From: Laura Gibbons
Sent: 03 May 2018 15:58
To: Planning.Responses
Subject: RE: Planning Consultation on: A/9/18/PL

APPLICATION **A/9/18/PL**

Site Address: The Caravan Site New Road A250 Buxington

Description of Works: Change of use of land to a Gypsy & Traveller Caravan Site consisting of 1 No. mobile home, 1 No. touring caravan, 1 No. amenity building & acoustic & close boarded fencing. This application is a Departure from the Development Plan.

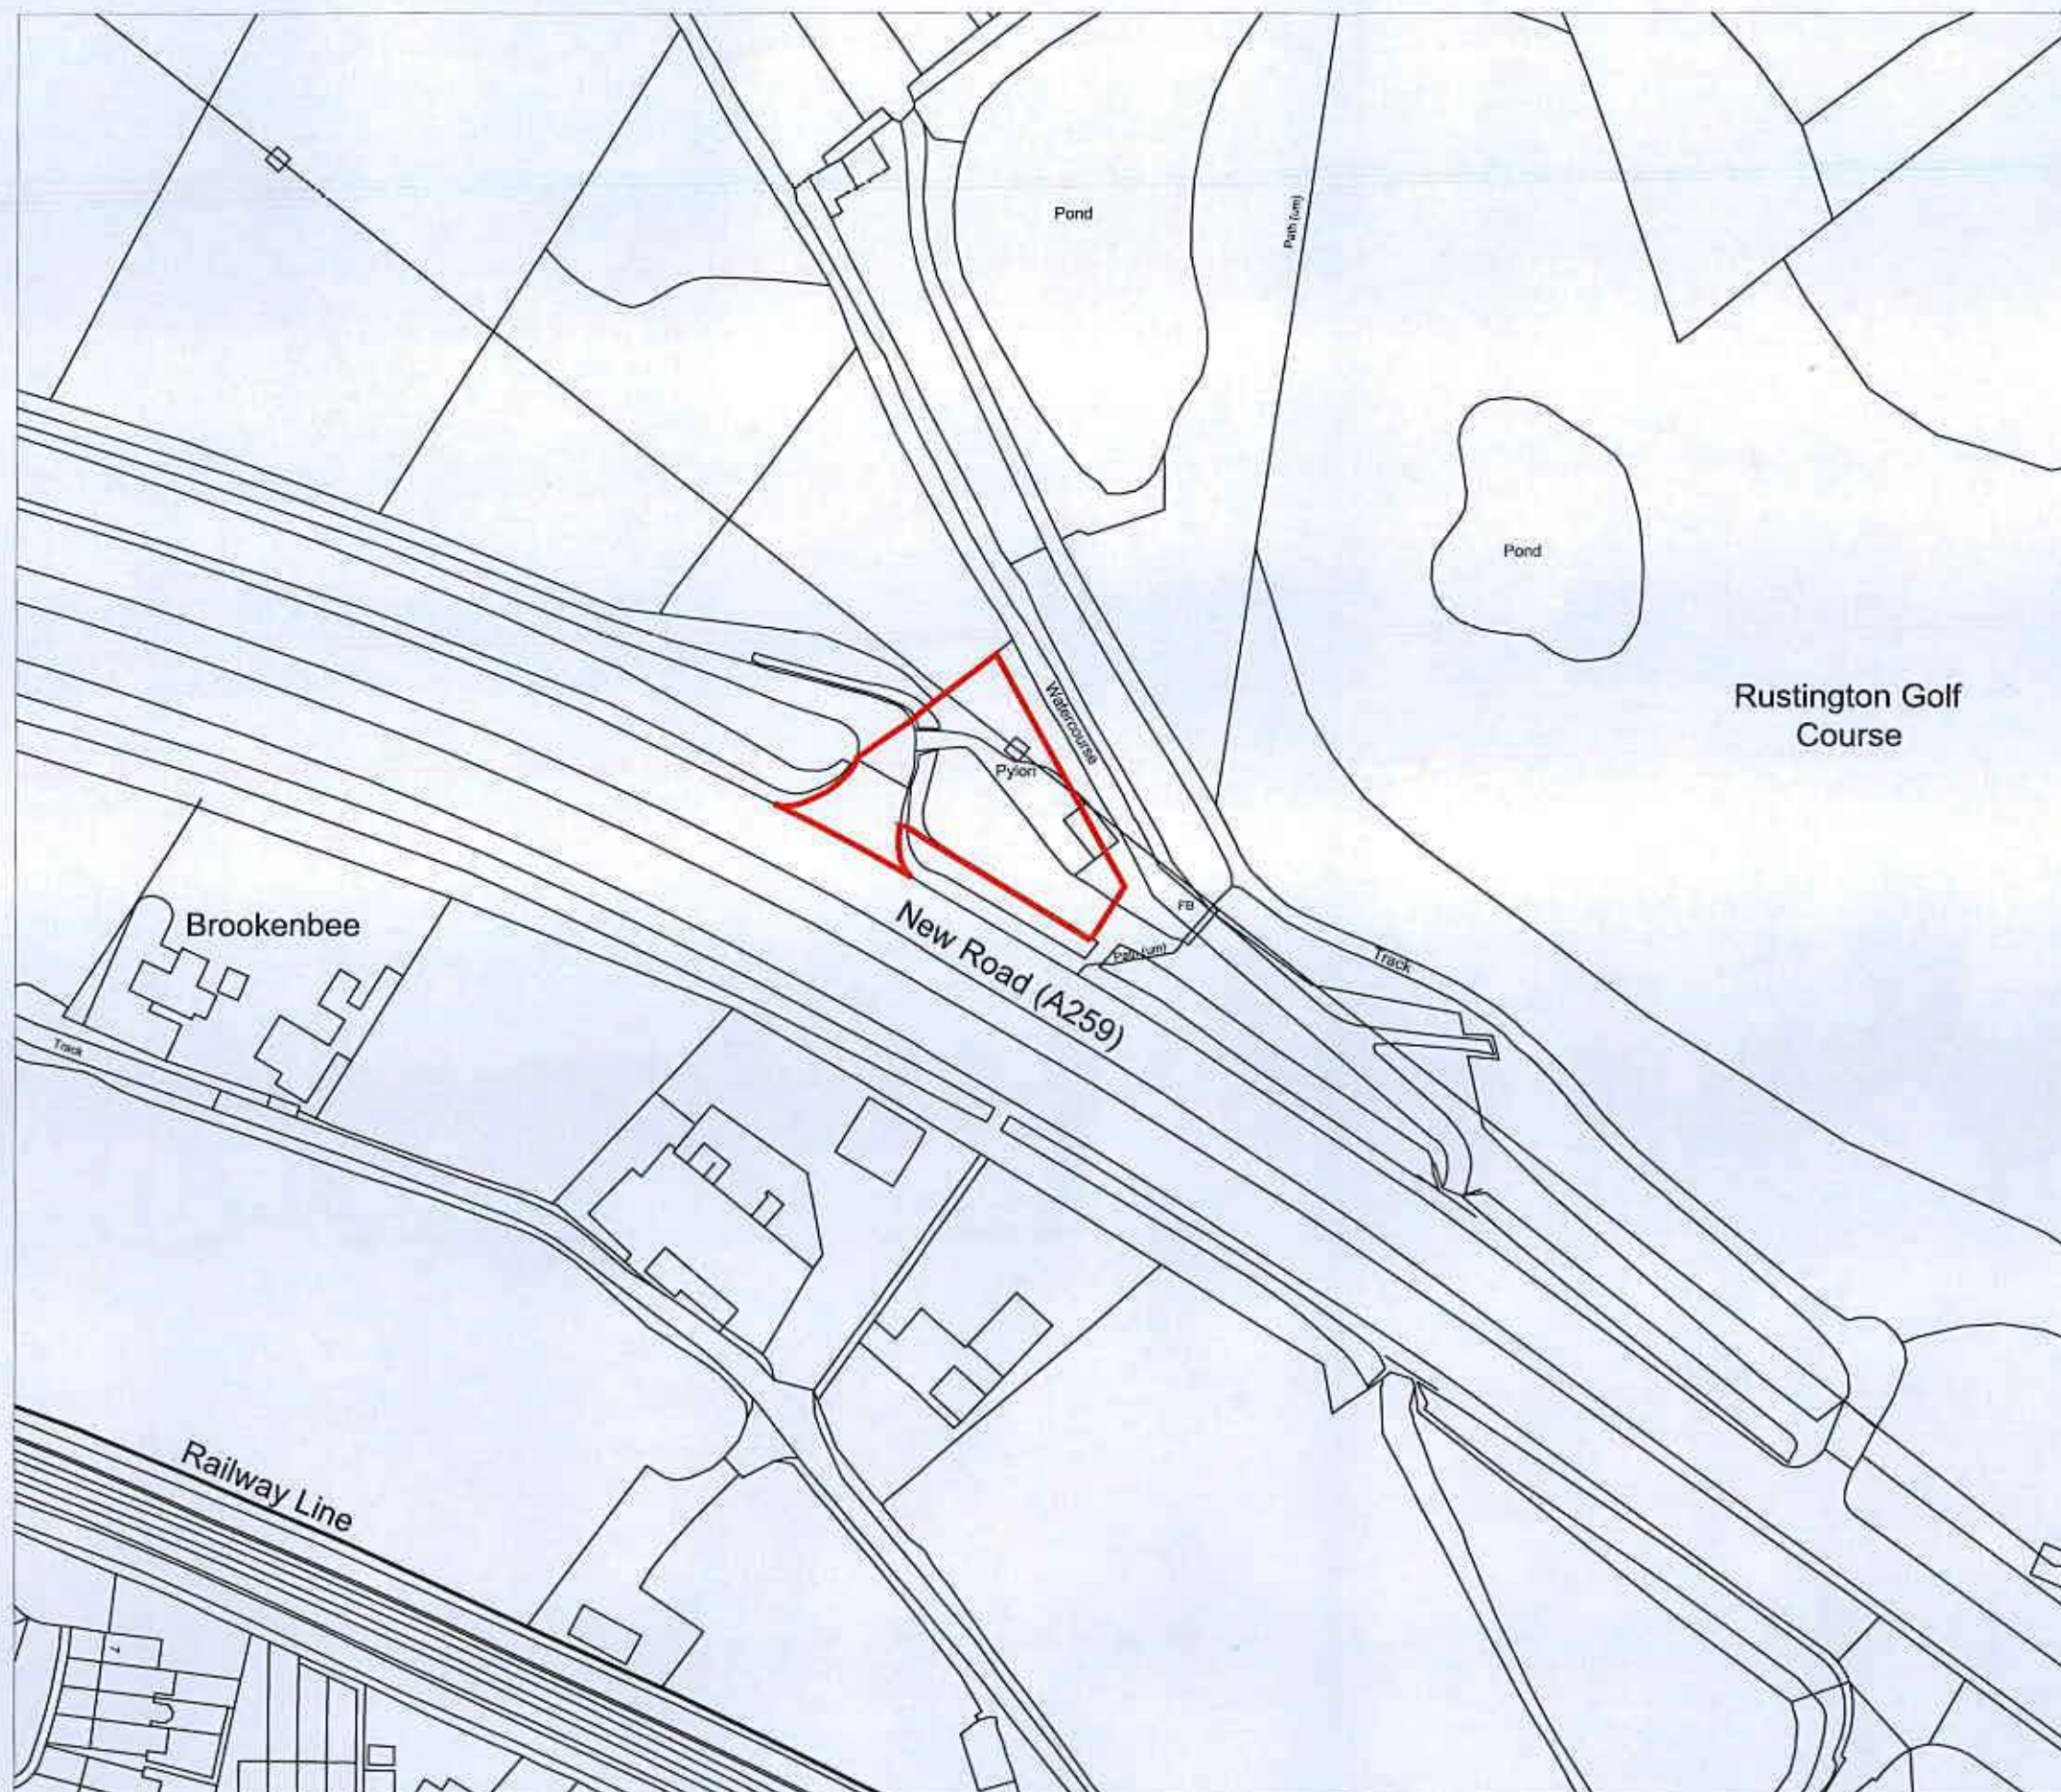
I note that plans show the site to be outside of Flood Zone 3, this contradicts our flood maps and the Environment Agency website. It is advised therefore that the Environment Agency are consulted, that an FRA and emergency access and egress statement are provided.
